From: Amanda Scholes on behalf of Planning.Responses
Sent: 21 December 2020 12:25
To: Planning Scanning
Subject: FW: Planning Application BE/115/20/HH 32 Norbren Avenue Bersted

Re: BE/115/20/HH

32 Norbren Avenue, North Bersted, Bognor Regis.

GROUND FLOOR - PROPOSED

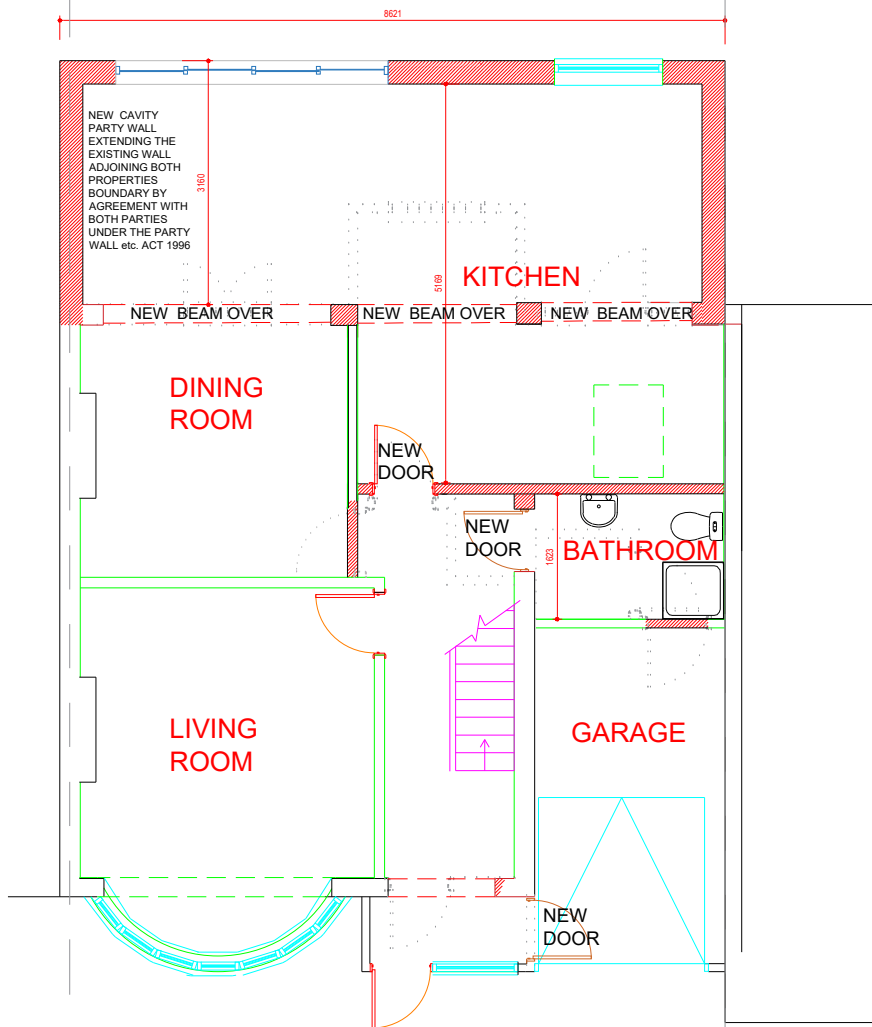
1. I would not want any part of my property to be damaged, I am thinking specifically of the gutter on the side of the conservatory, which when it was constructed, does not overhang the boundary between the two properties. I would expect the extension to be constructed within the properties boundaries.

2. We have noticed on the plans reference to the party wall act. It states that the new cavity party wall (the extension building wall) extending the existing wall straddling property boundary by agreement with both parties under the party wall act. I am concerned that there could be damage to our conservatory. Also will it affect any future development from this side of the boundary in the future?

PROJECT	
32 Norbren Avenue	
Bognor Regis	
P021 5HE	
DRAWING	
Proposed Elevations	
SCALE 1:100 • A3	DATE July 19
DWG.NO. 1903-01-04	REV.

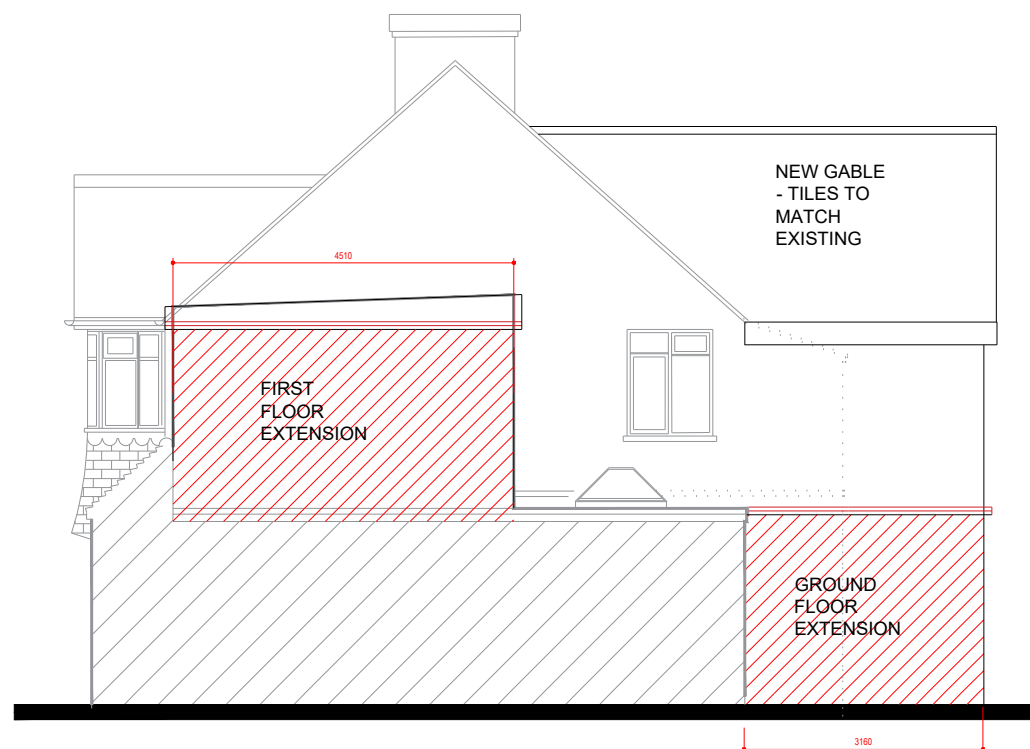
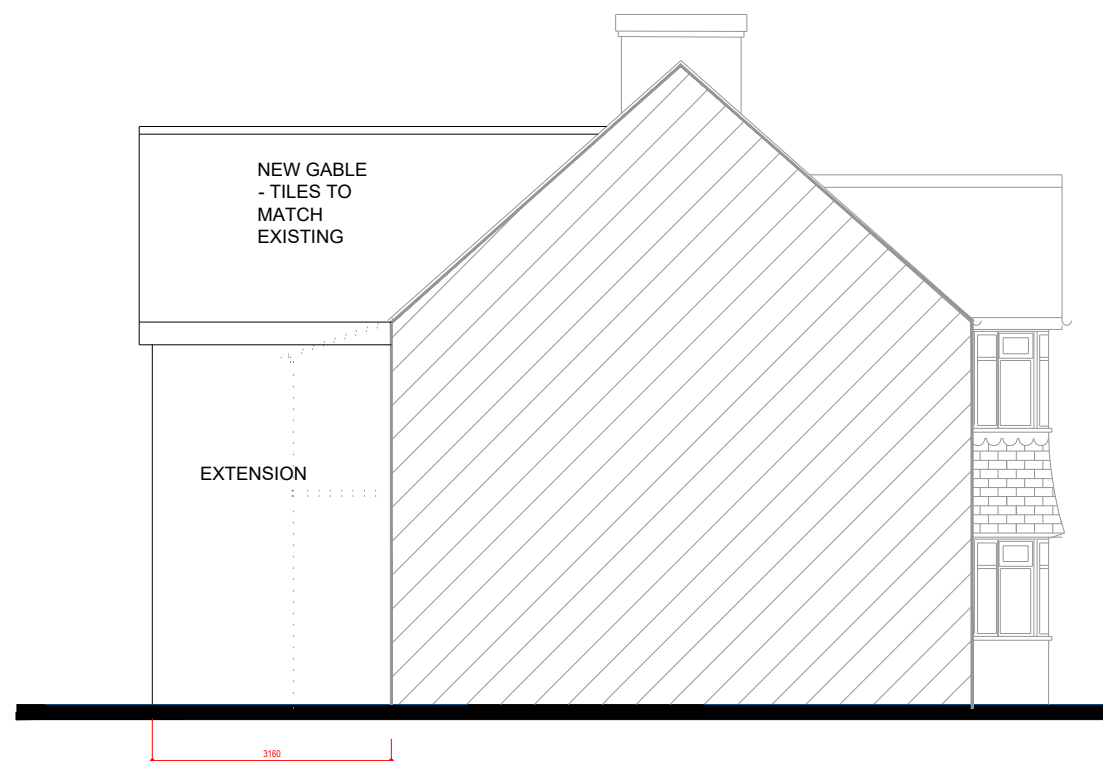
3. The wall which would overlook our conservatory I feel should be rendered and painted white as this will alleviate the problem of loss of light to our bedroom above the conservatory at the back of the house.

4. Finally and this may be something I would have to come to an arrangement with my next door neighbour the construction of a snow guard along the gutter which overhangs the conservatory. This is to prevent tiles from the sloping roof slipping down and crashing into the roof of the conservatory.
